STATE OF WASHINGTON  
DEPARTMENT OF ECOLOGY

November 2, 2017

RE: Ecology and Kittitas County site visit to The Commons at Dry Creek

SHEET NUMBER
 A1.0

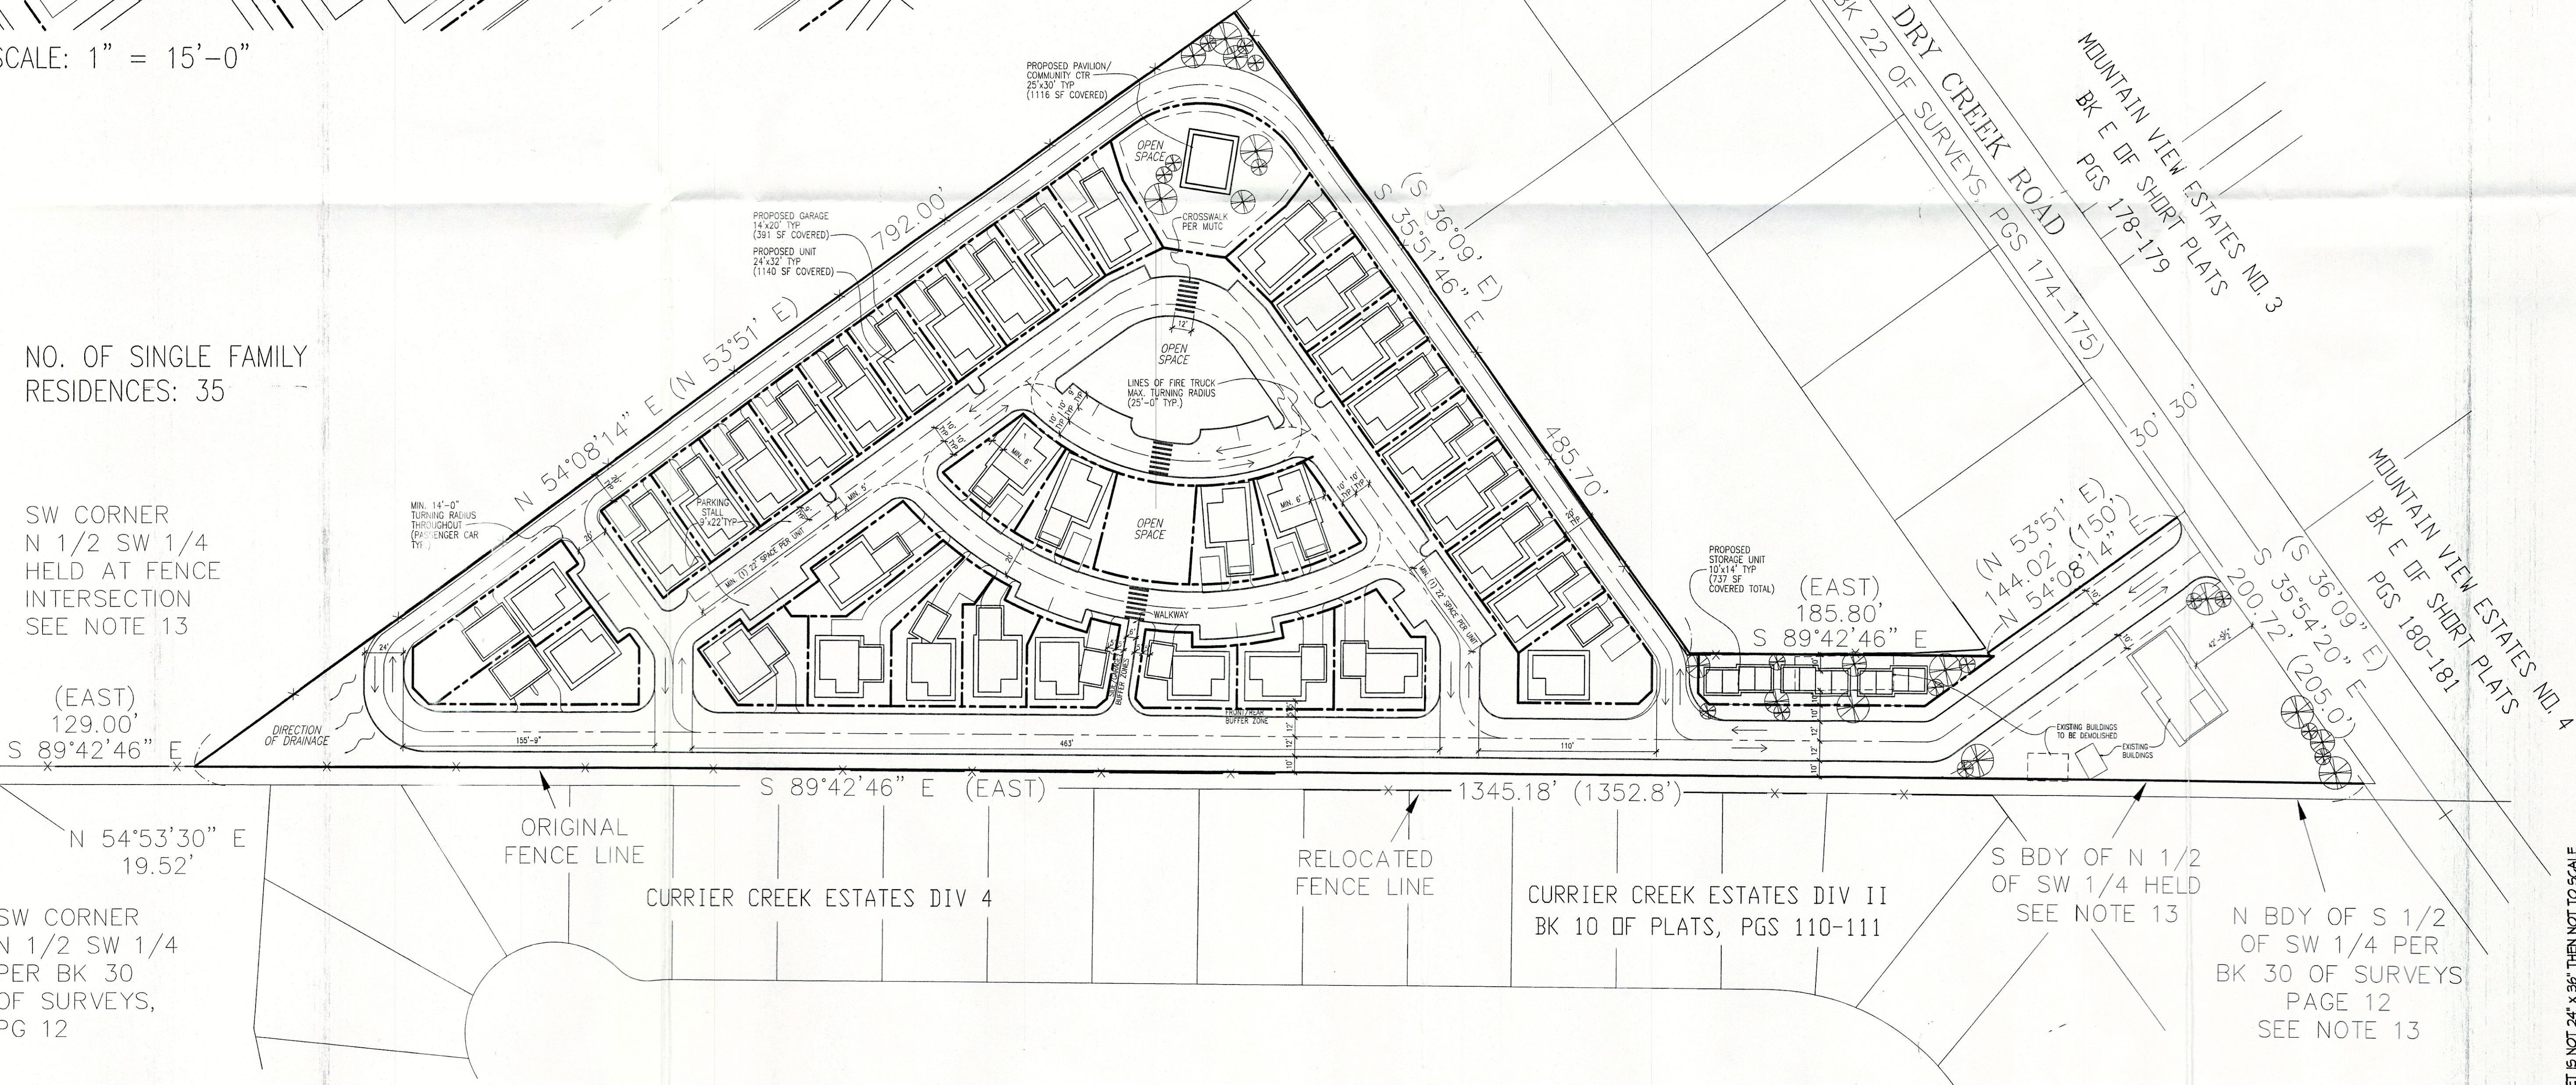
Large, dense patches of sedges (*Carex* sp.), a species typically found in wetlands and wetter growing conditions, were noted within topographic features near the center, northwest, eastern, and southern boundaries of the project site. Topographic and elevational changes were noted by Ecology staff, with topographic depressions and a topographic swale extending from the western

boundary towards the south-southwest project boundary, situated centrally through the project site.

Prior to further review of proposed site development plans by Kittitas County, Ecology recommends a wetland delineation be conducted of the project site and adjacent Currier Creek corridor by a qualified professional using methodology according to the US Army Corps of Engineers Wetland Delineation Manual (1987) and the Arid West Regional Supplement (Version 2.0).
